**University of Sydney's Campus Improvement Program 2014-2020 State Significant Development (SSD 6123)**

**University of Sydney Campus Improvement Program 2014-2020 – State  
Significant Development (SSD 6123) – Submission and Objection to EIS**

01 ENGINEERING - SHEPHERD STREET ELEVATION PROPOSED

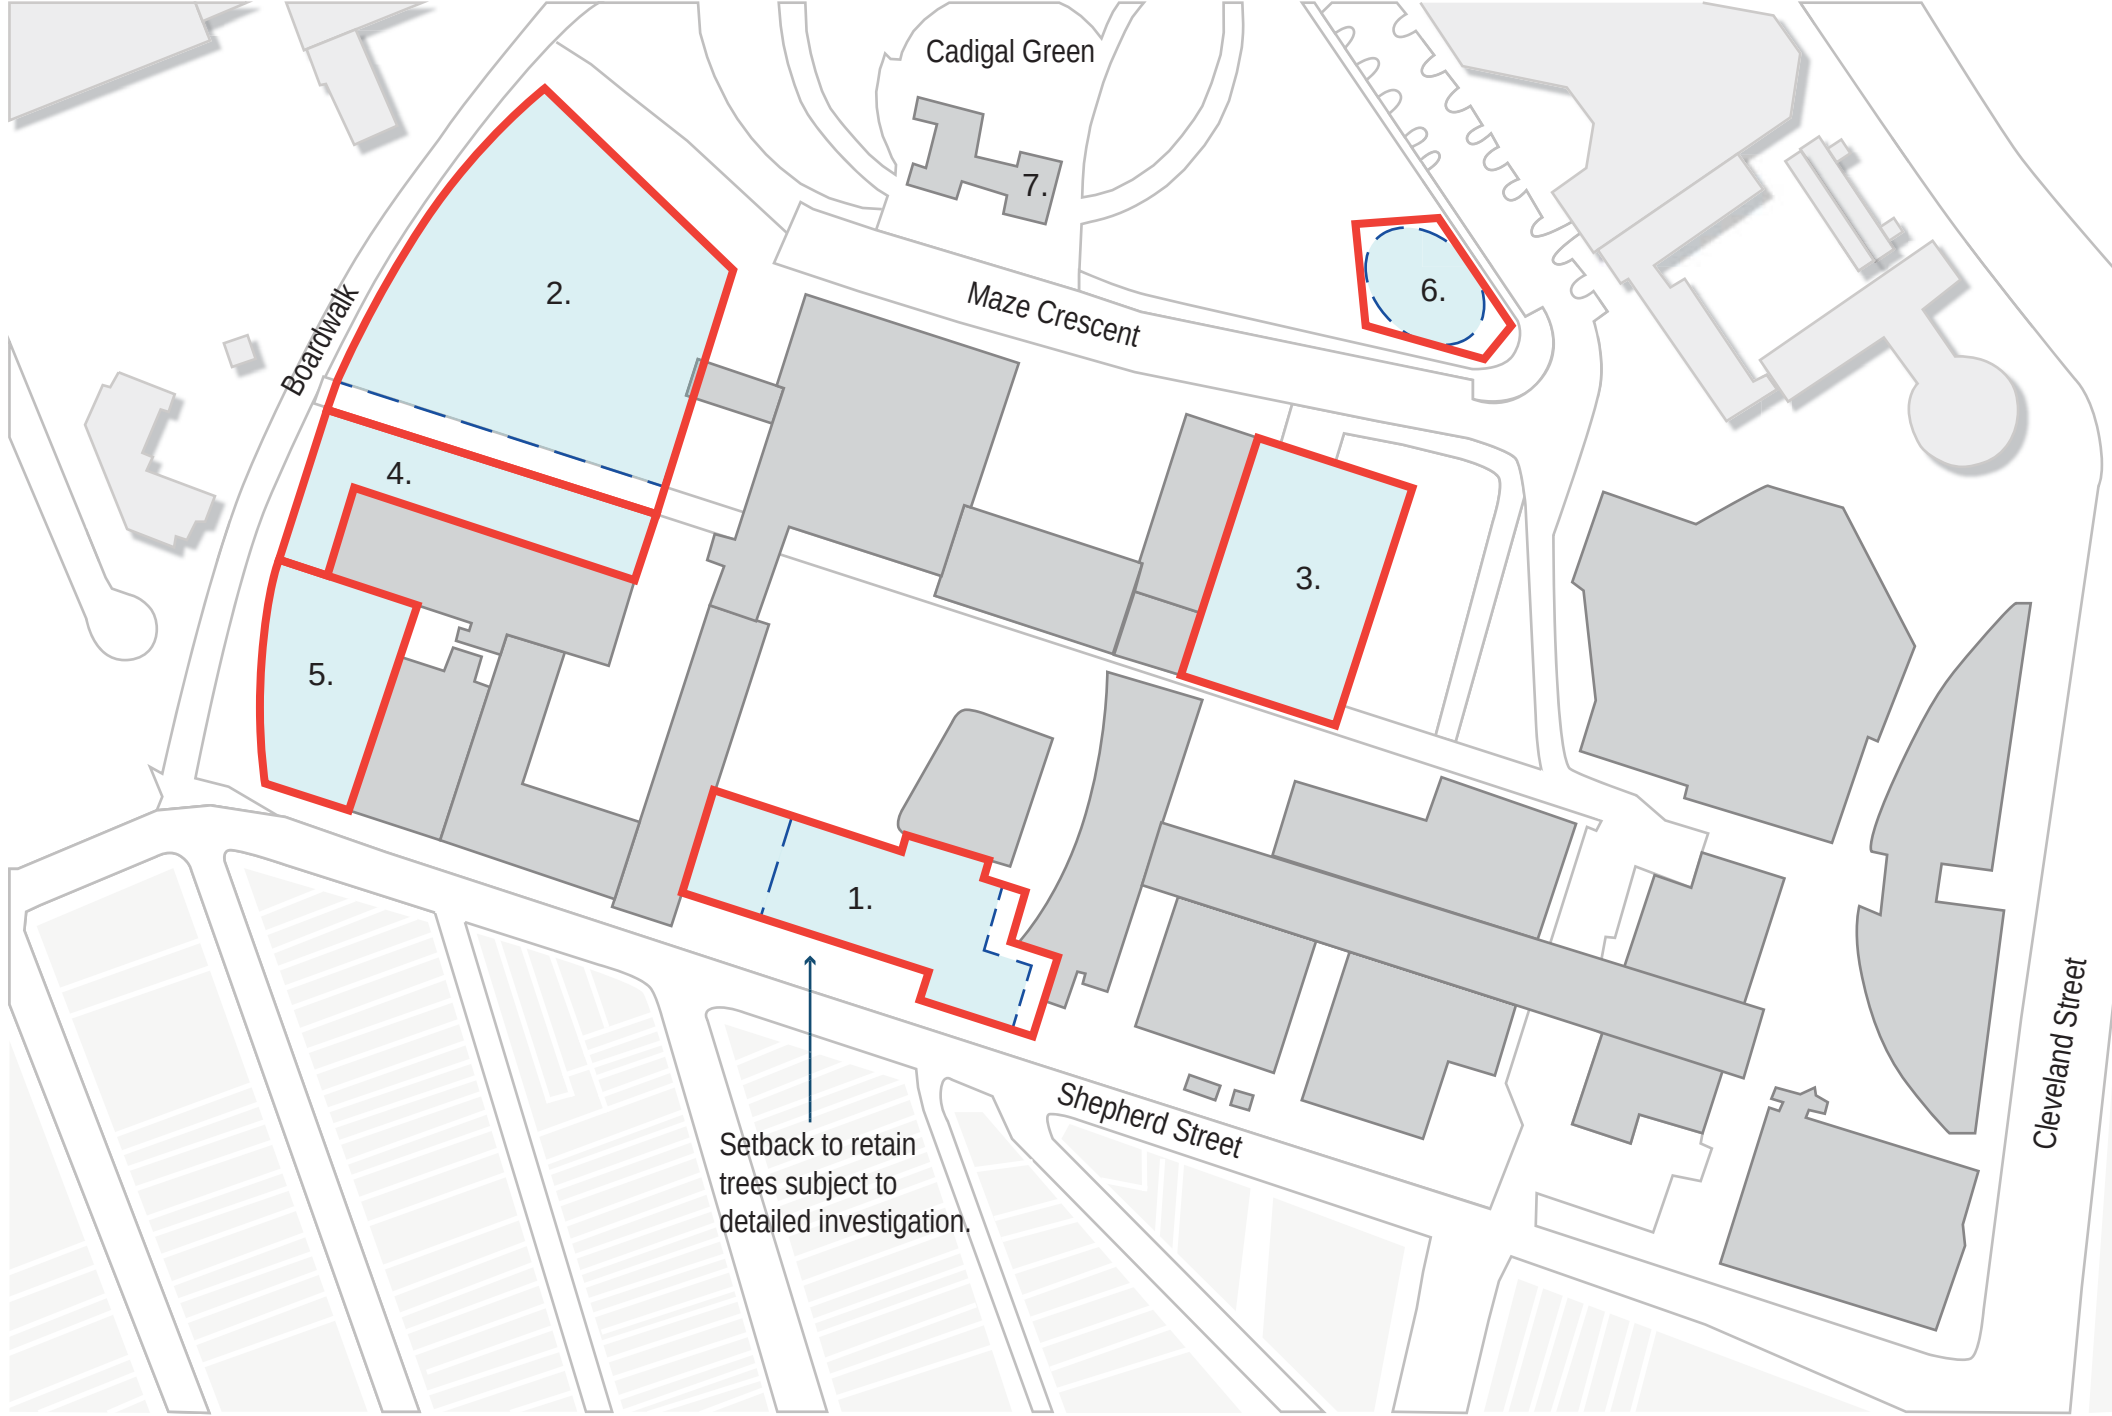
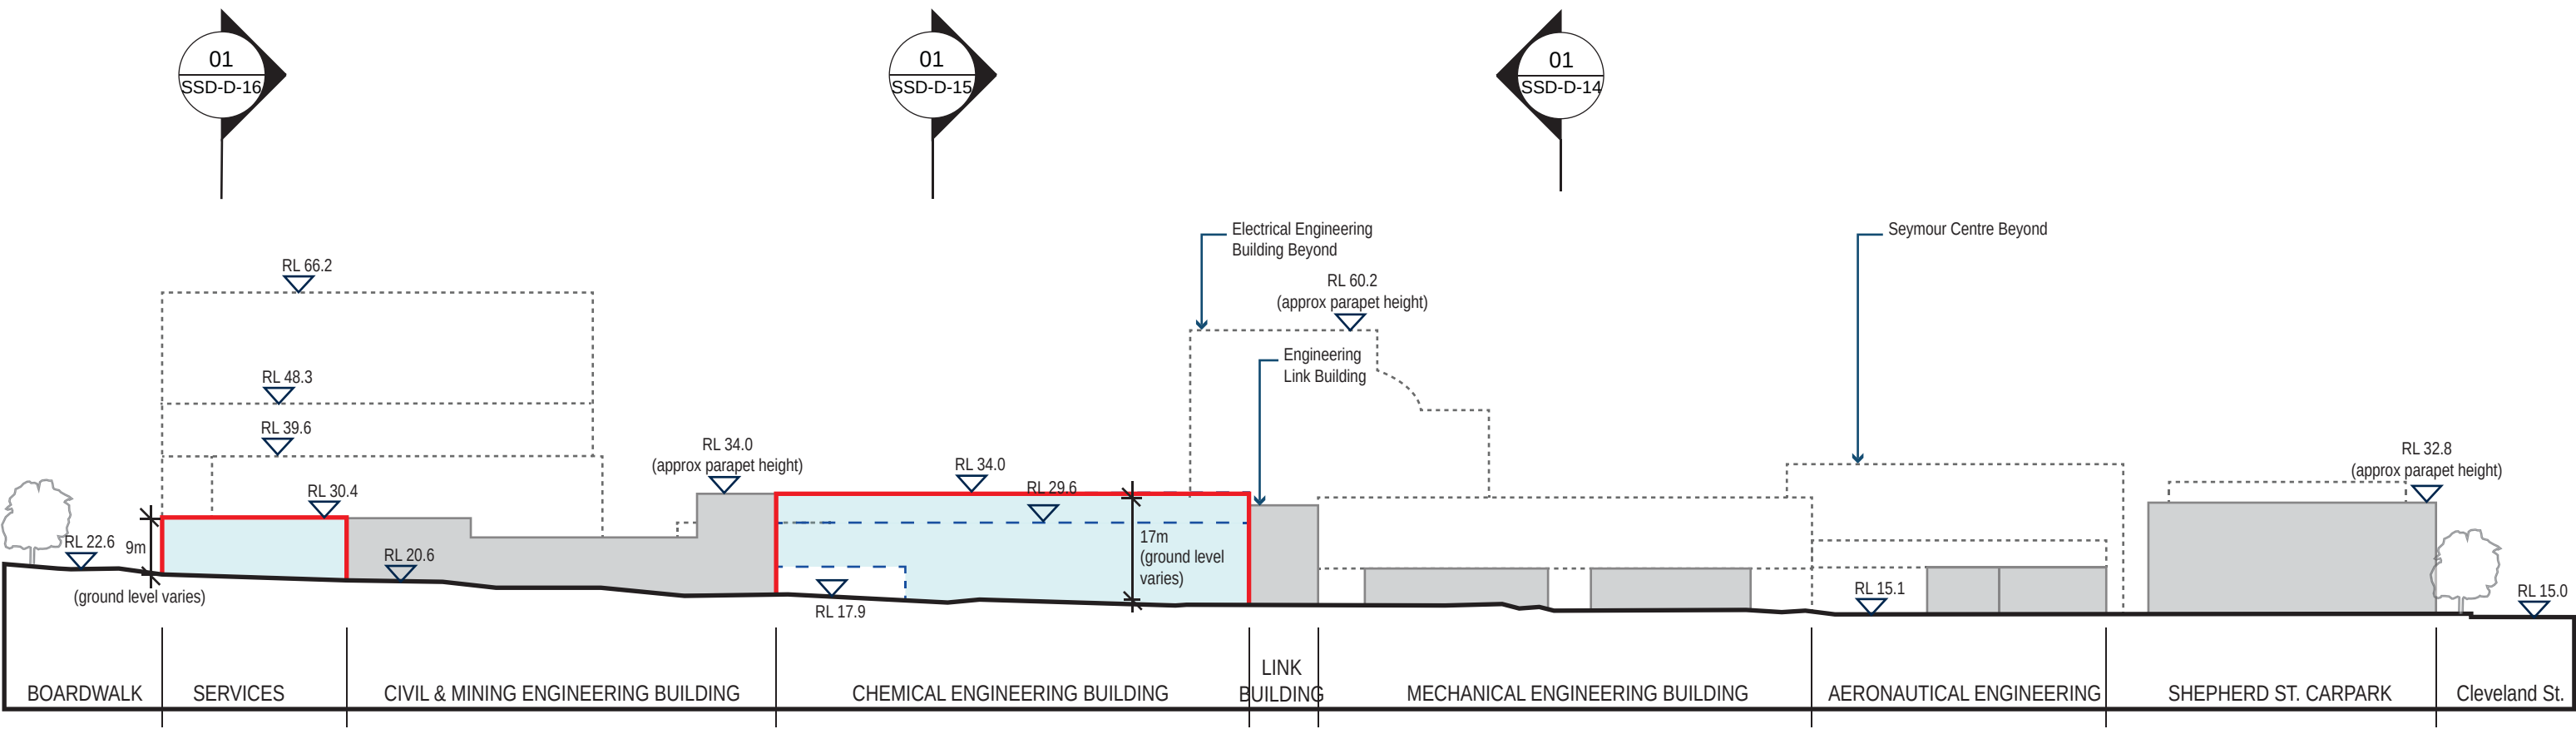
I object to the proposed 3 storey building in Shepherd Street and the "multidisciplinary building" opposite the Sports Centre both of which will overlook residents homes in Shepherd Street, Calder Road, Lander Street, Boundary Street and Abercrombie Street.

I object to the University's plan to destroy Darlington's Eucalypt Grove on Shepherd Street at the interface of the engineering campus and residential Darlington and to replace it with a 3 storey building overlooking resident's homes.

Indeed a rare, albeit small buffer zone, exists already between the large ugly engineering buildings on Shepherd Street and the much smaller nearby residential terrace houses. The University is proposing to destroy this buffer zone, a grove of 19 mature Eucalypt trees, along with the fauna that inhabit it and use it as a transitional bridge, and construct a 3 storey building overlooking resident's yards and homes thus seriously degrading resident's amenity.

The University should implement the Council Plan by not destroying the Darlington Eucalypt Grove. If the grove were bulldozed and replaced by a 3 storey building the open vista from Shepherd St to the Engineering Lawn and the landmark PNR building beyond would be lost.

01 DARLINGTON TERRACES - PROPOSED ENVELOPE PLAN

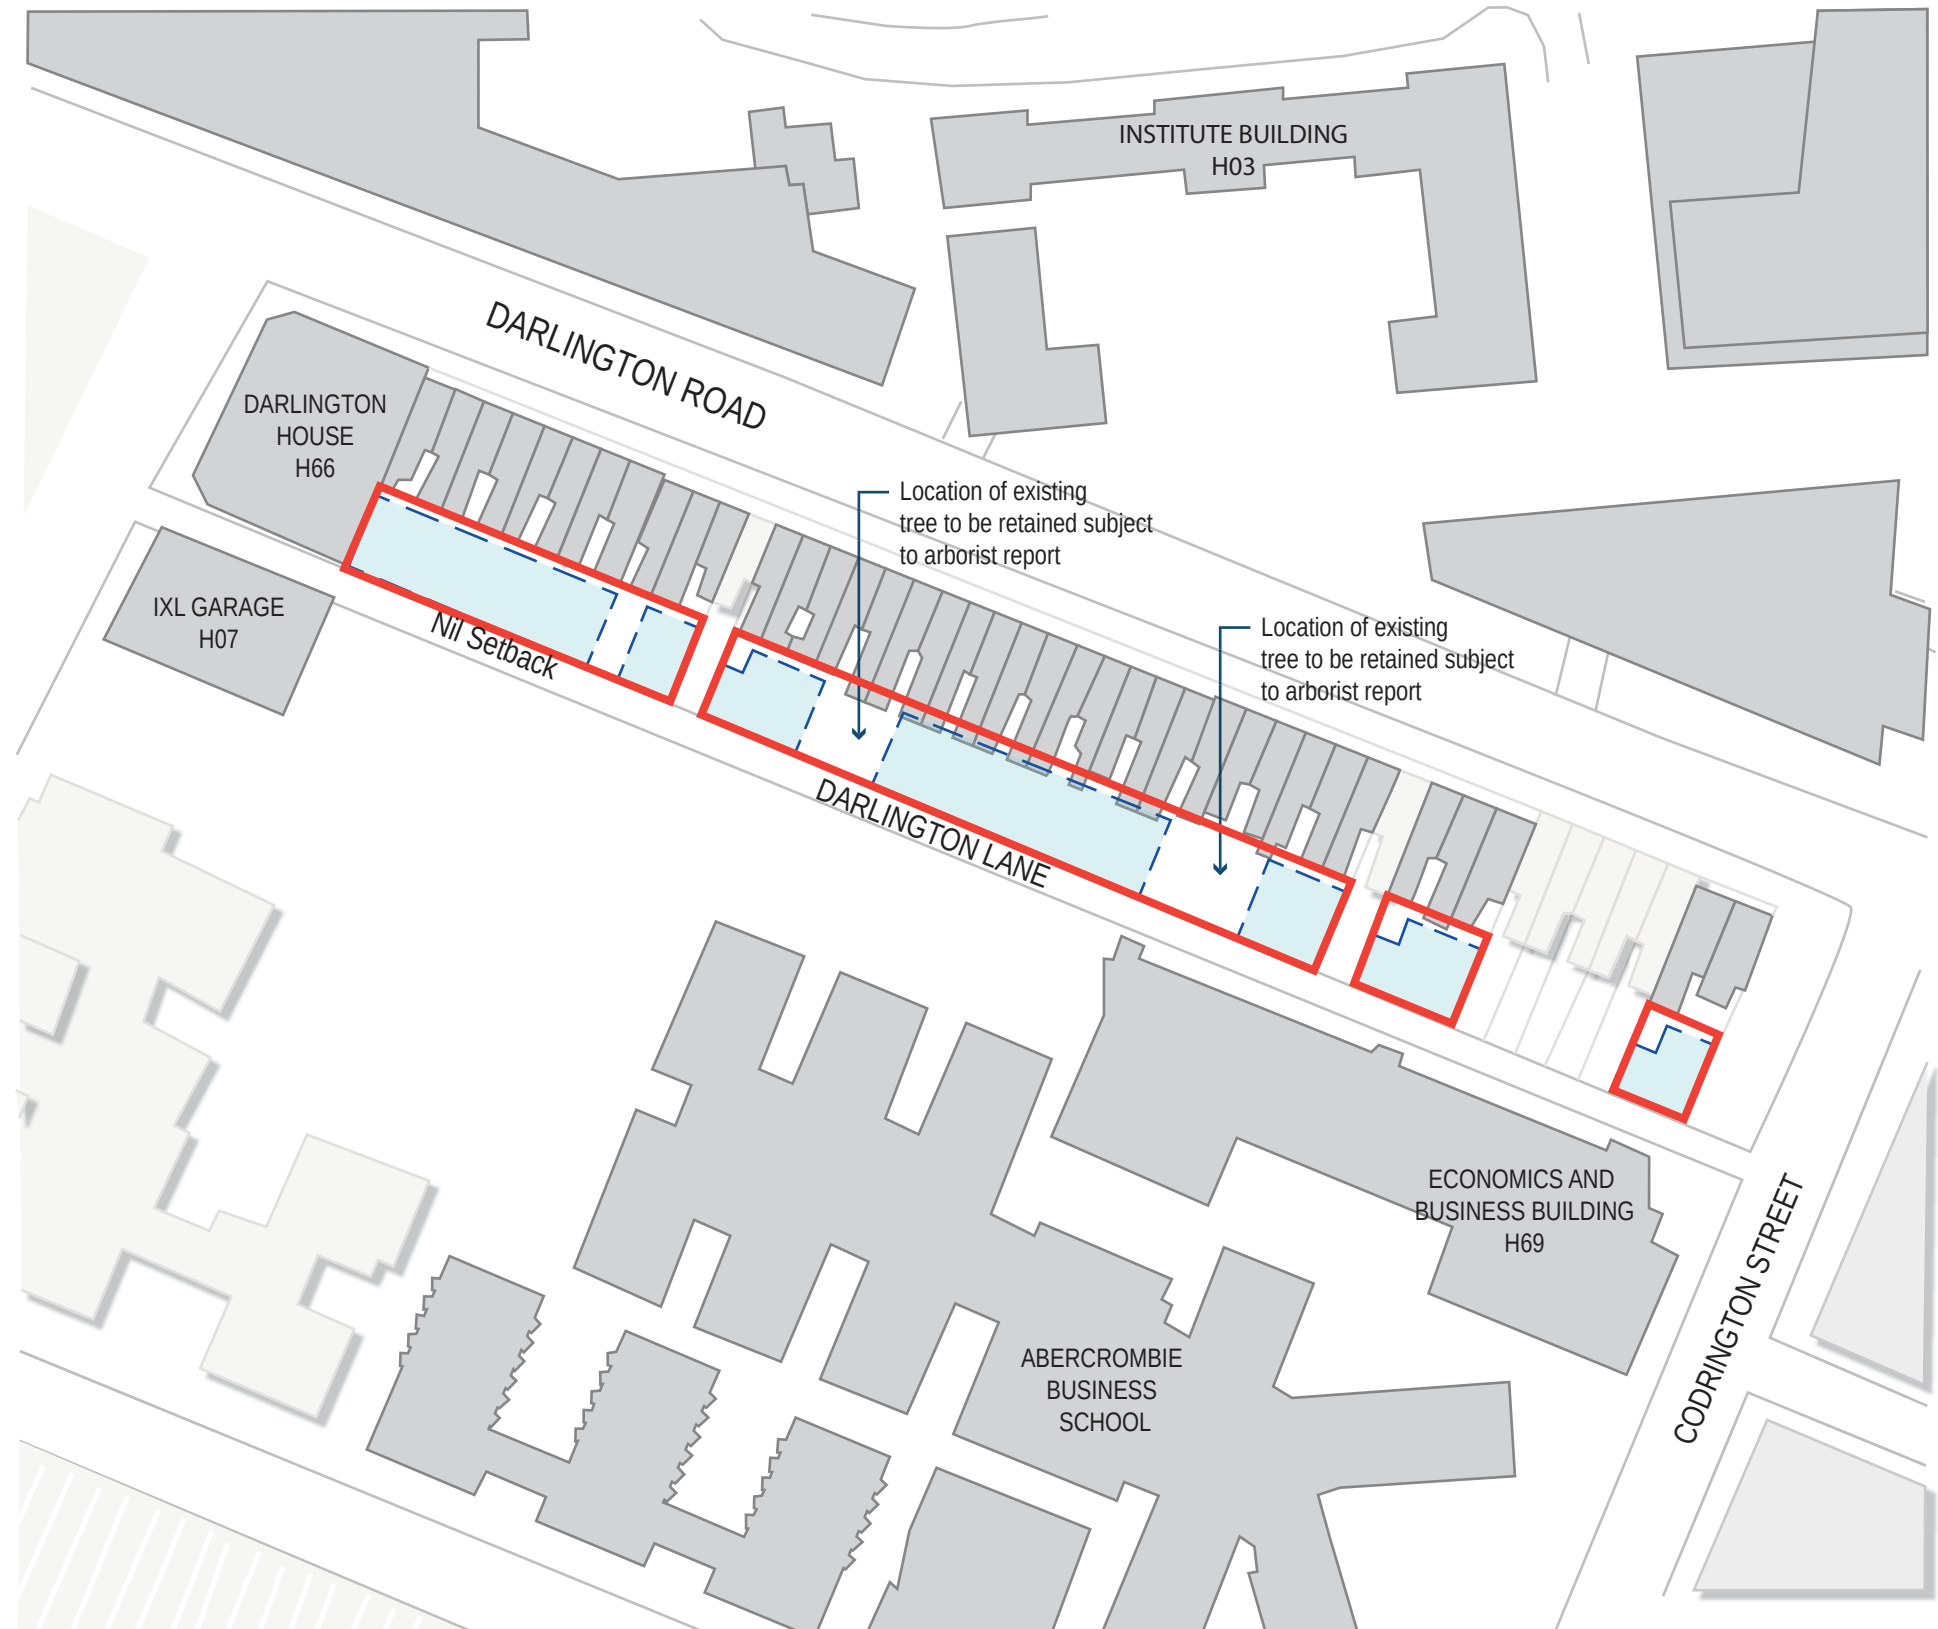
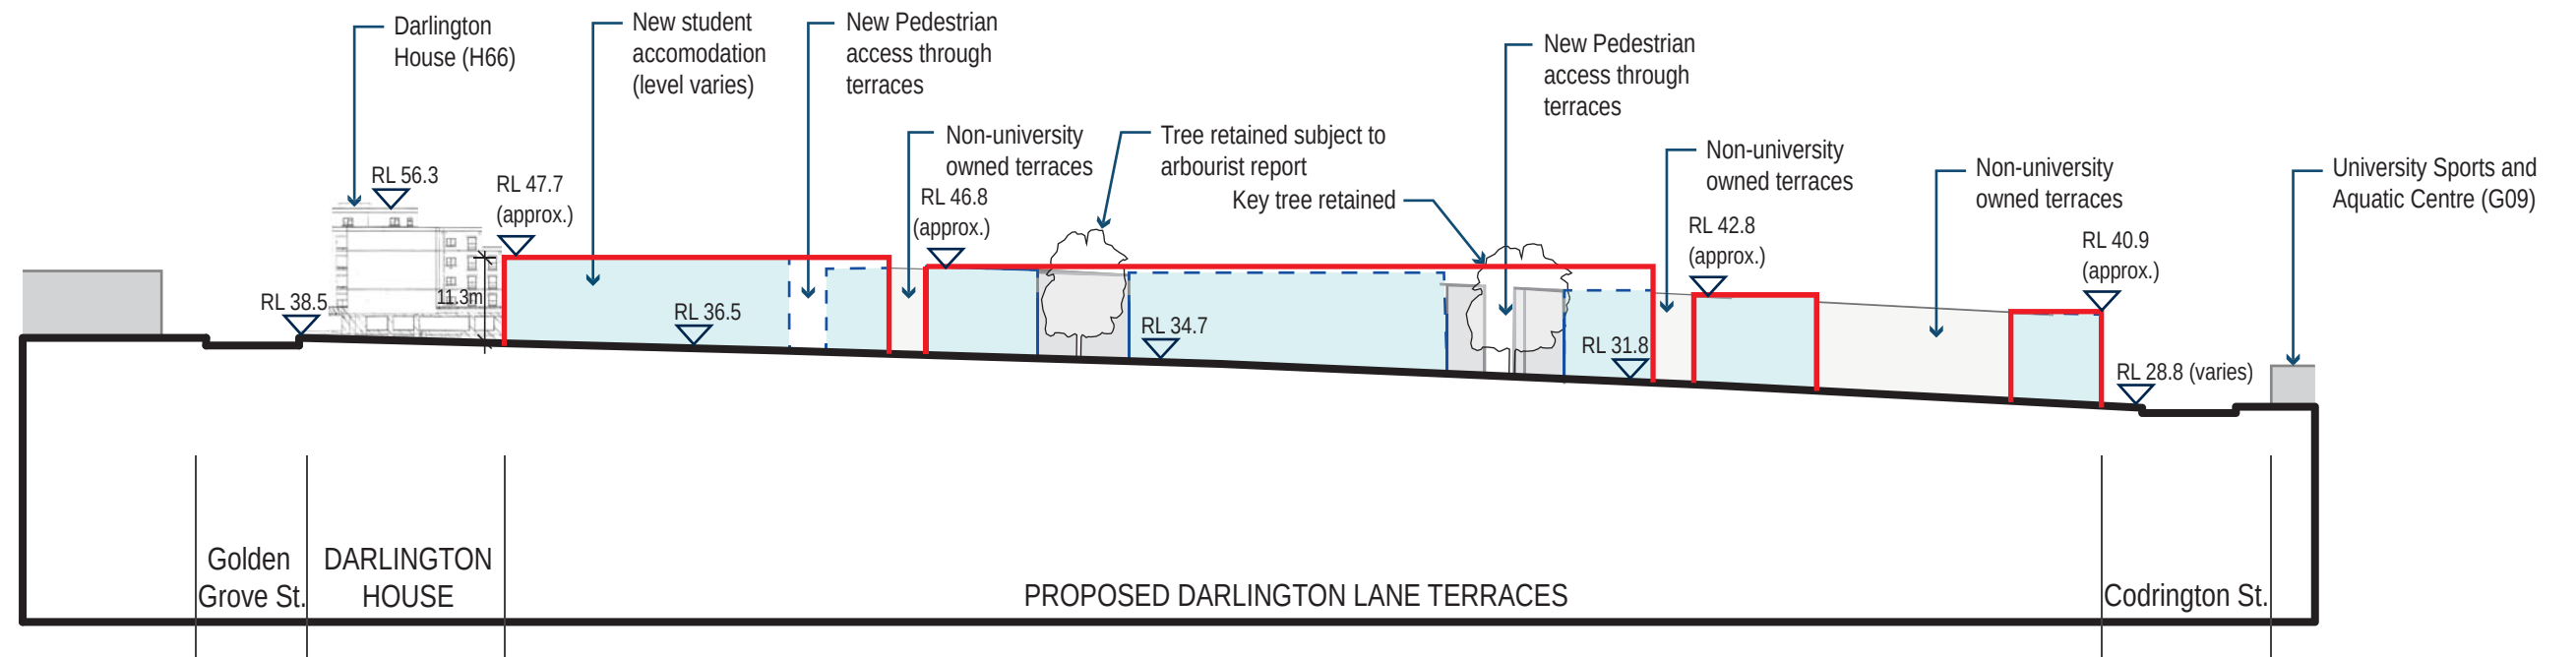
I object to the University's proposal to completely infill the backyards of every heritage listed terrace house (bar 3) from 86 – 130 Darlington Road with 3 storey extensions.

The National Trust has given these terraces an "A" rating – "highly intact". The University should not be allowed to degrade the heritage value of these terraces which are very close to the Golden Grove Conservation Area.
